PLANNING CONSULTATION RESPONSE

Application No	2025/1031
Proposal	Discharge of conditions, 3 (Biodiversity Gain Plan), 4 (HMMP), 5 (CEMP-B), 6 (Ecology Mitigation), 7 (Bicycle Storage) and 8 (Boundary Treatments) of application 2024/1007 - Change of use from Residential Care Home (Class C2) to 24no. apartments (Class C3).
Address	Residential Home, Rockley Dene, Park Road, Worsbrough, Barnsley, S70 5AD
Date of Consultation Reply	18/12/2025
Consultee	Highways Development Control

Drawing title
EXISTING AND PROPOSED SITE PLAN

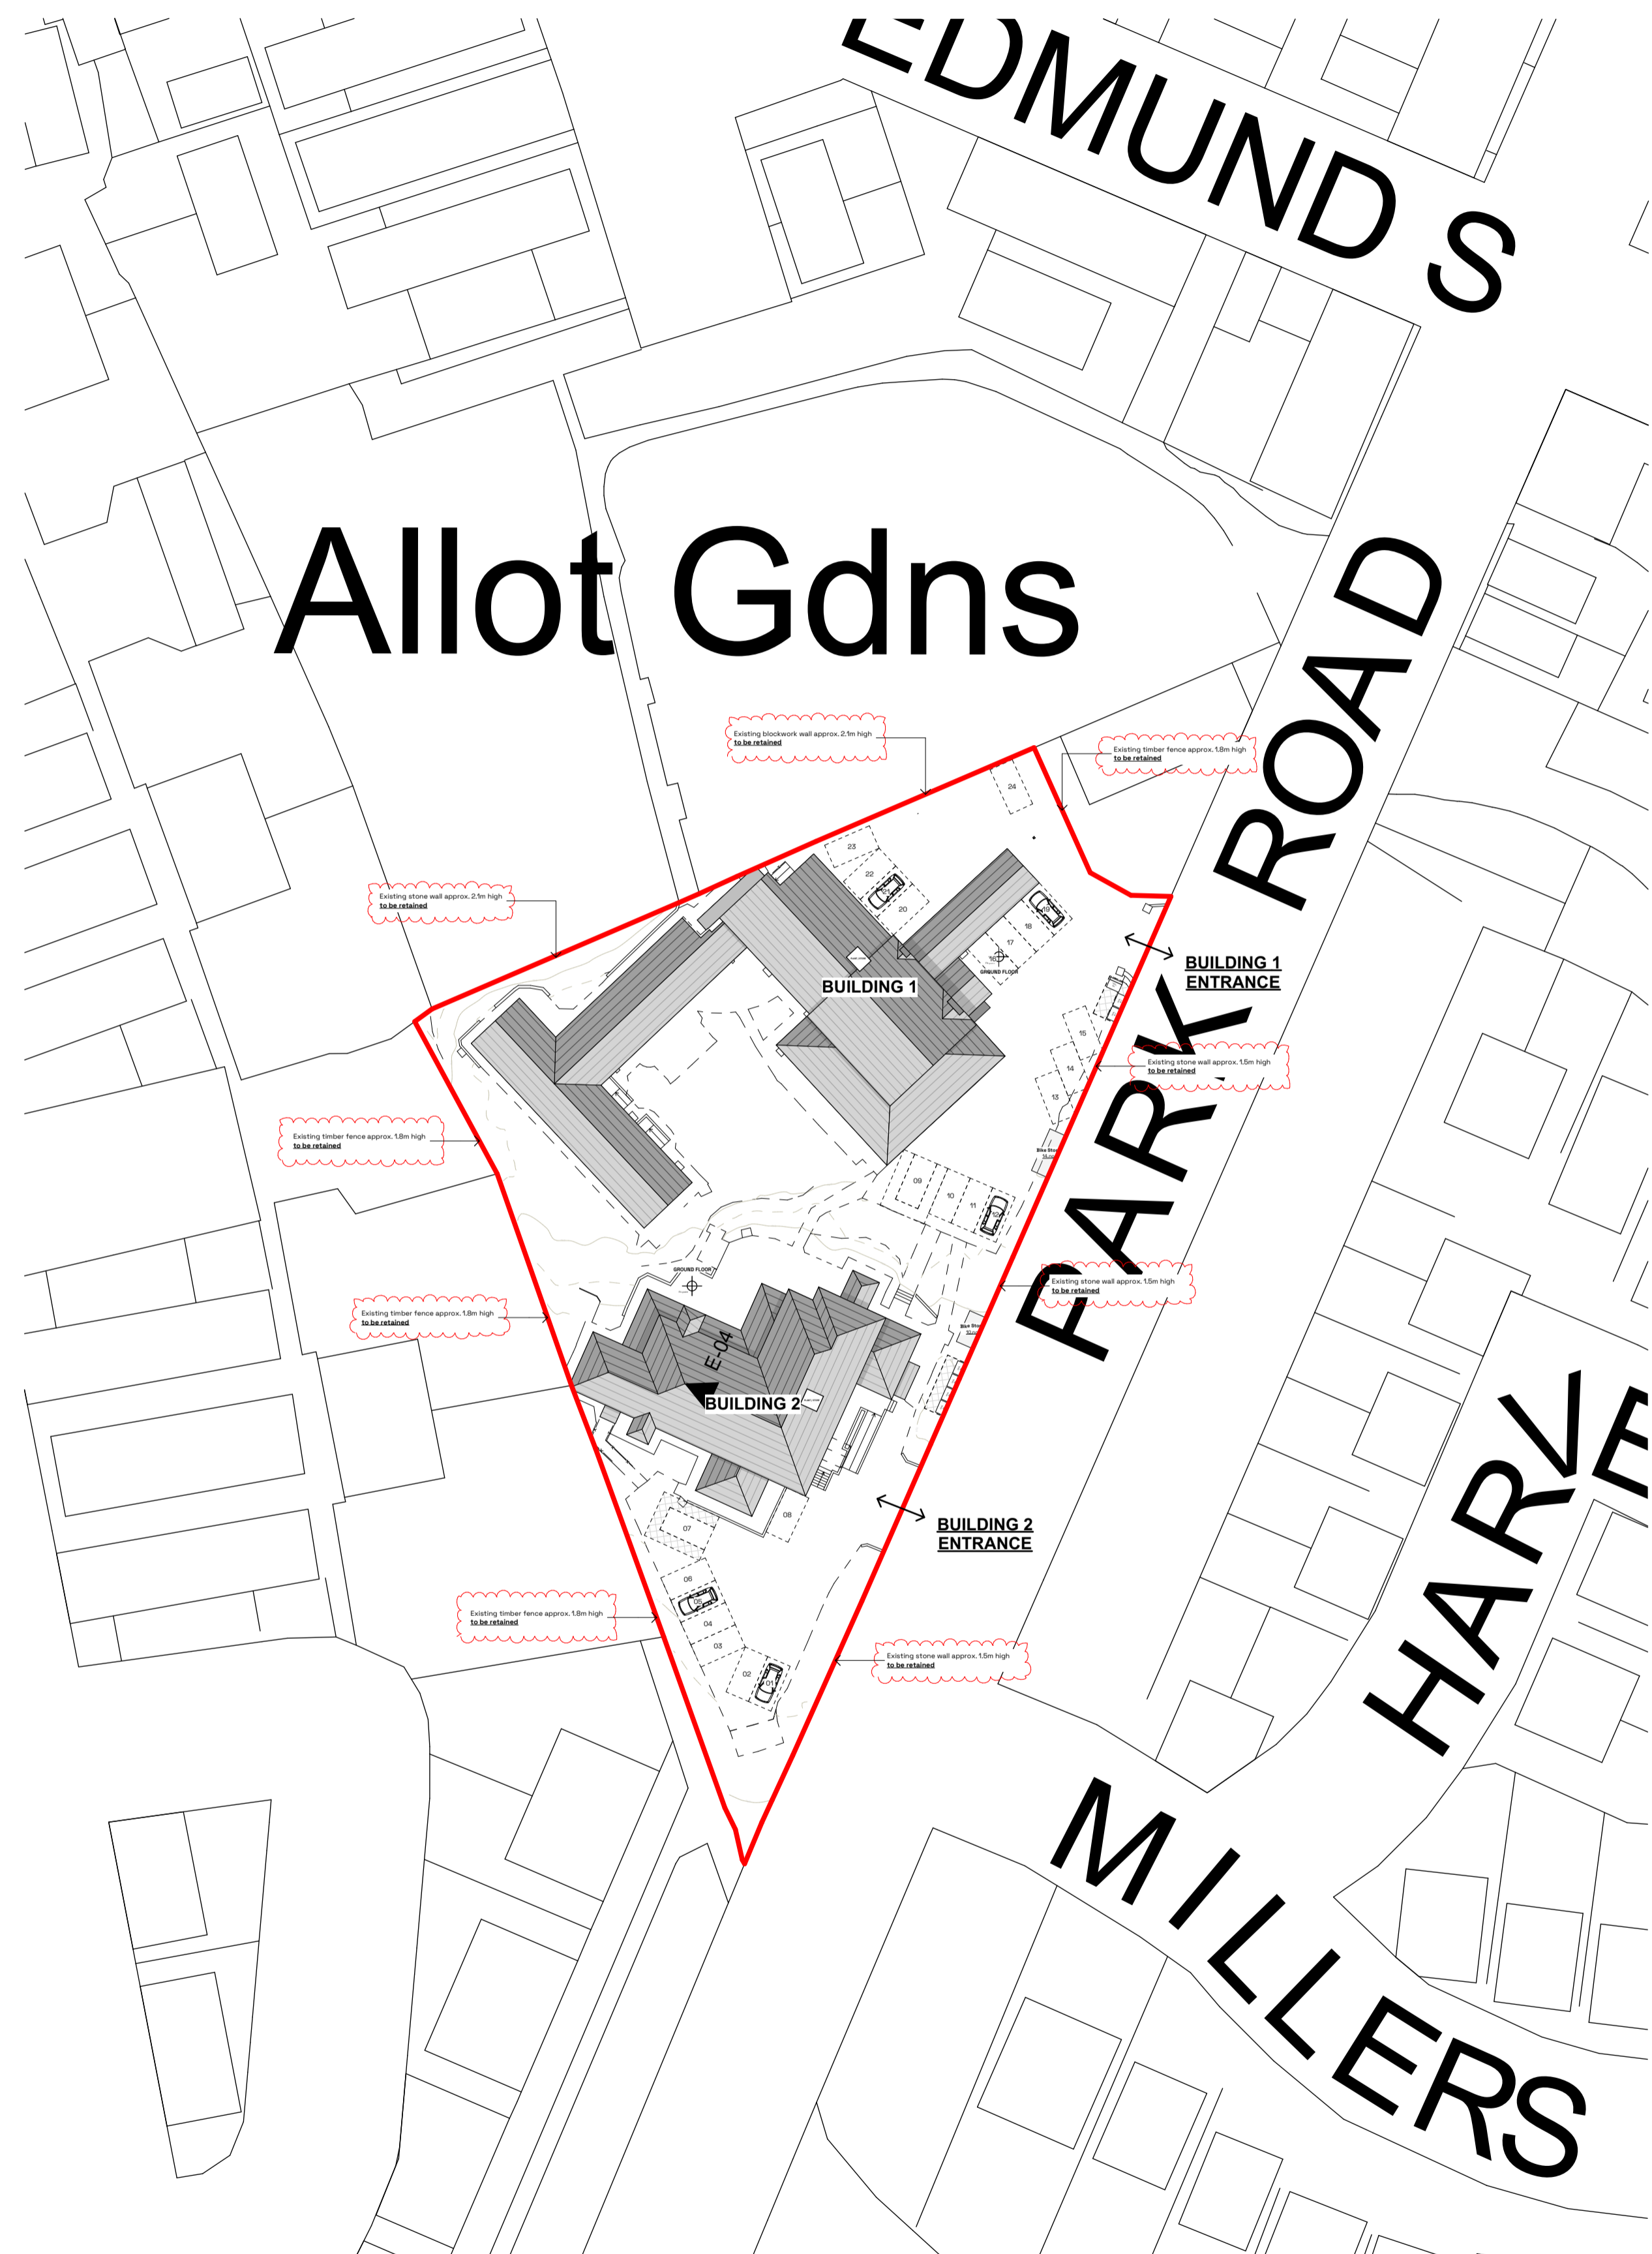
I note that the conditions requiring discharge were not specifically requested by Highways Development Control, however I have reviewed the cycle storage and can confirm that the shelters proposed are both secure and covered and are therefore acceptable from a HDC perspective.
